Re: Kelso Crescent Multi-Level Warehouse, Moorebank (SSD-58978472)

Liverpool City Council was invited to provide comments during the exhibition of a State Significant Development Application for a Multi-Level Warehouse at 20 Kelso Crescent, Moorebank (Lot 2 DP 521146 and Lot C DP 327378).

Attachment A – Detailed Comments

2 OVERALL SOUTHERN ELEVATION
1: 500 A-204

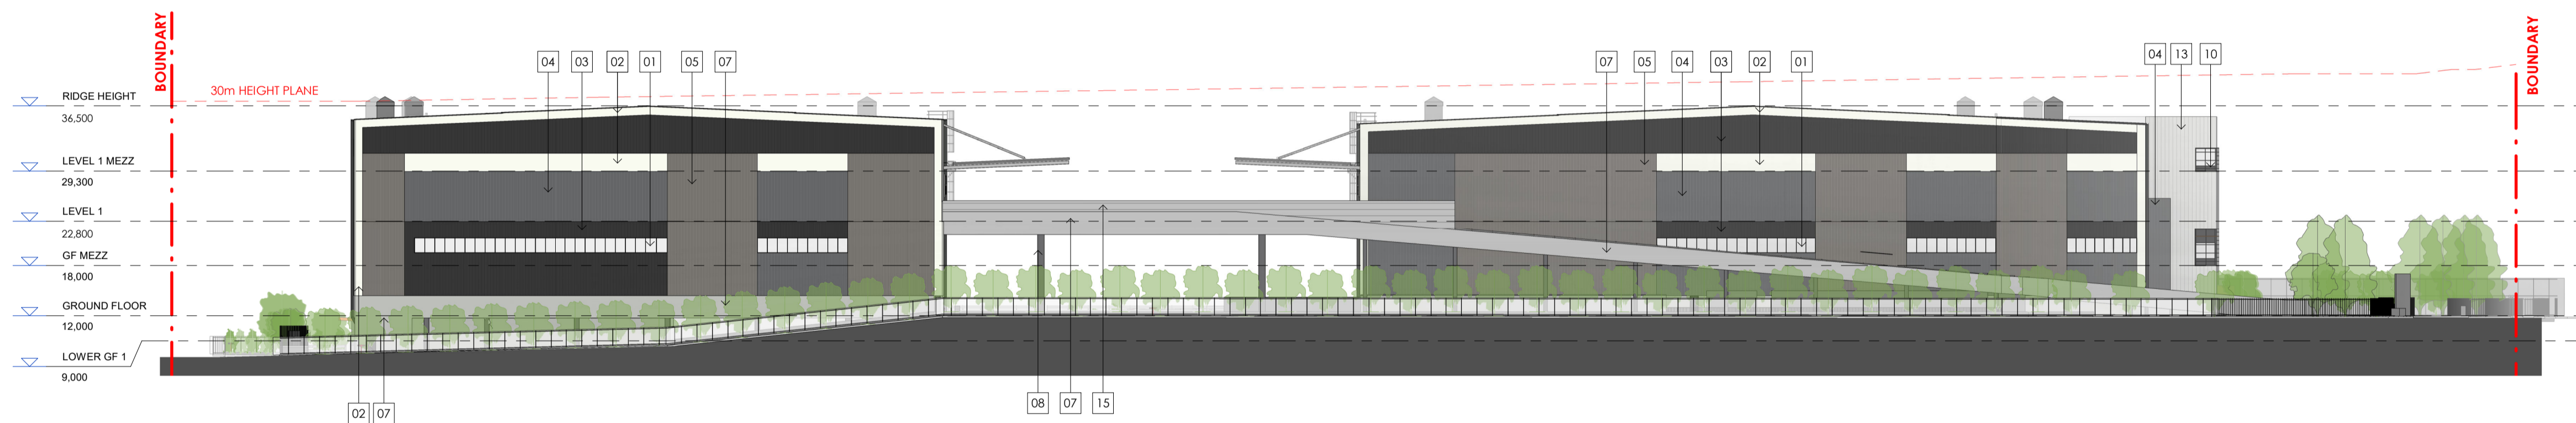
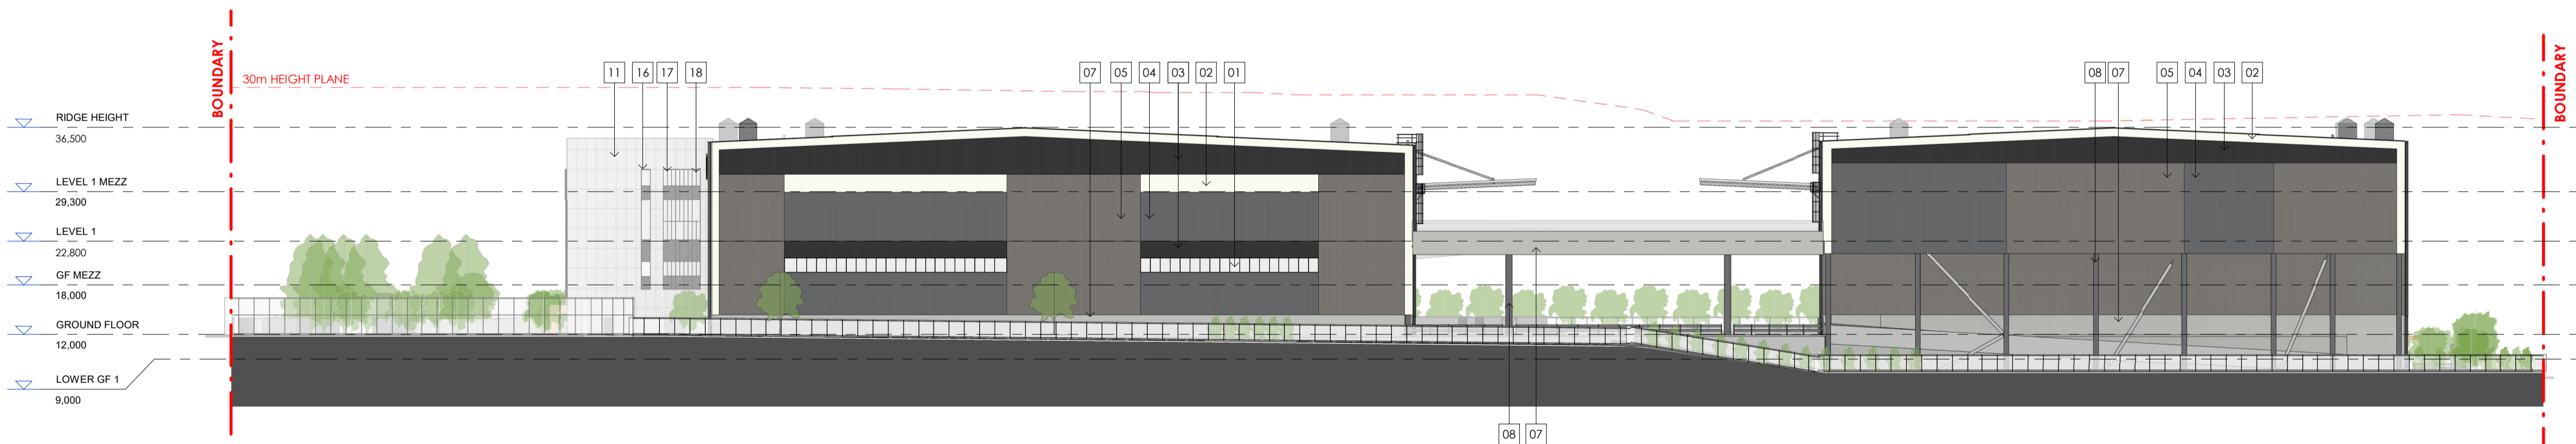
The ground level of the southern elevation on Seton Road is mostly blank wall and not an acceptable street interface. The DCP Part 7 Objectives include to "*ensure the creation of an attractive streetscape character and Control - 'A development must use architectural elements to articulate facades and minimise large expanses of blank walls.'*" The ground level is critical to the character, pedestrian experience and passive surveillance of the street. Council staff recommends the applicant improve the ground floor façade design, through additional windows, permeability, material differentiation, texture and/or articulation. Continuing the approach of the upper levels to lower levels could also be explored.

scale	As indicated	A1
project no	250211	
date	08.10.25	
dwn	SP	
dwg no	250211 - DA-301	
issue	A

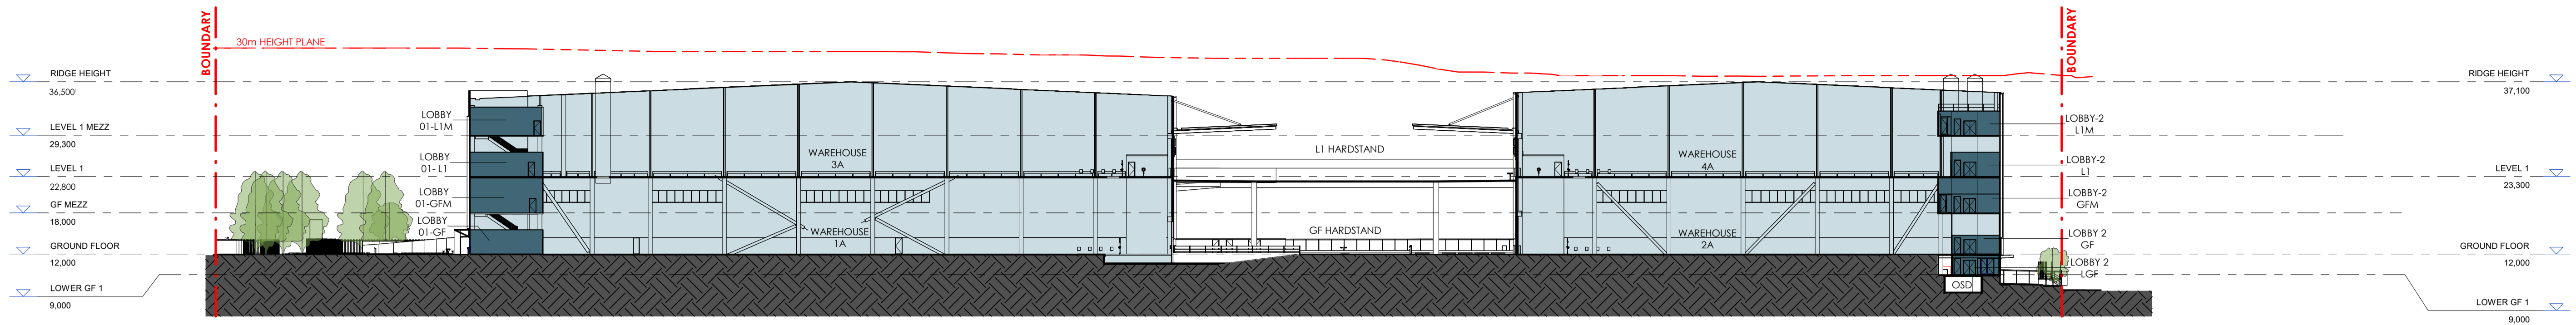
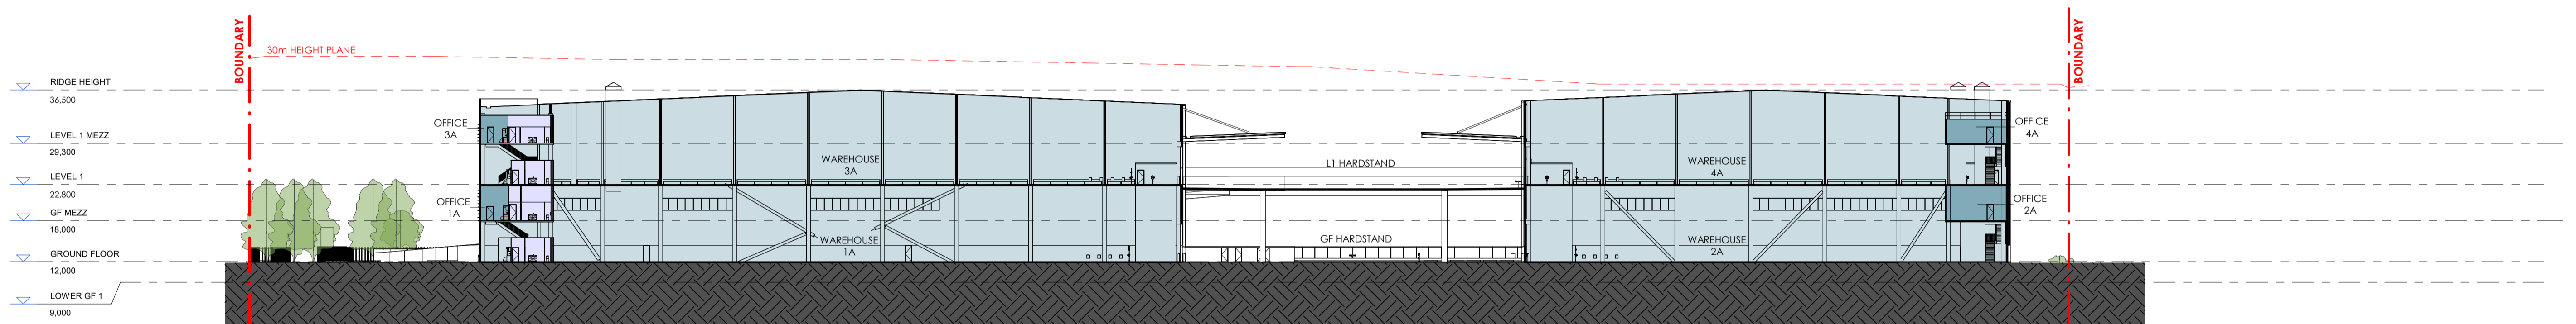
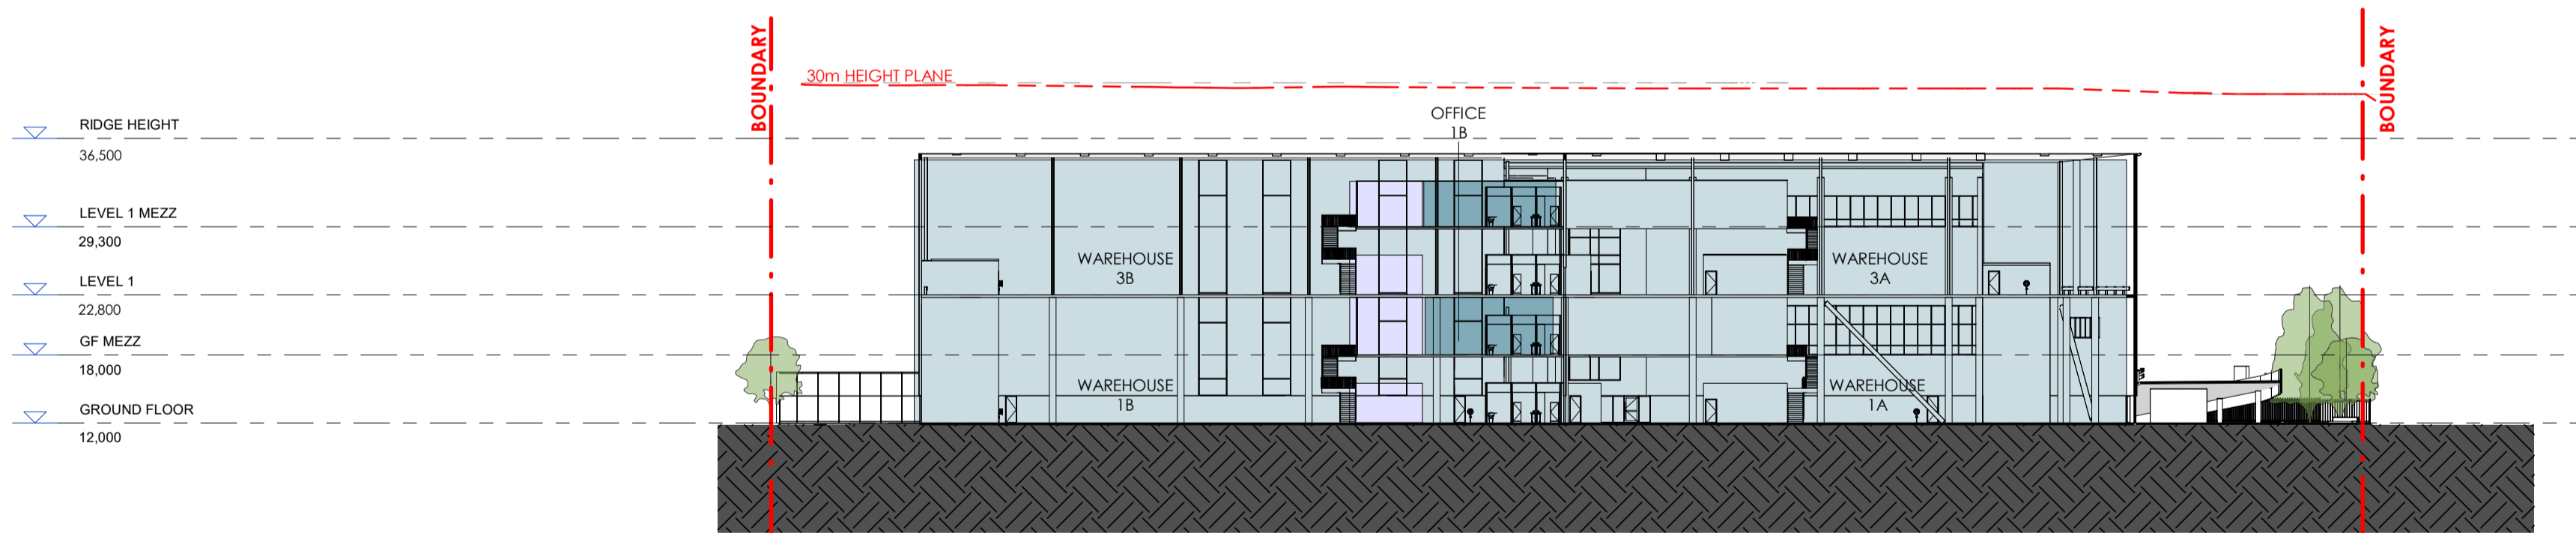
Furthermore, it is requested the applicant show the existing ground line dashed on the sections, to enable for a review of the proposed levels and whether it is appropriate for the site and street interface. The design of the development should be consistent with the Liverpool DCP.
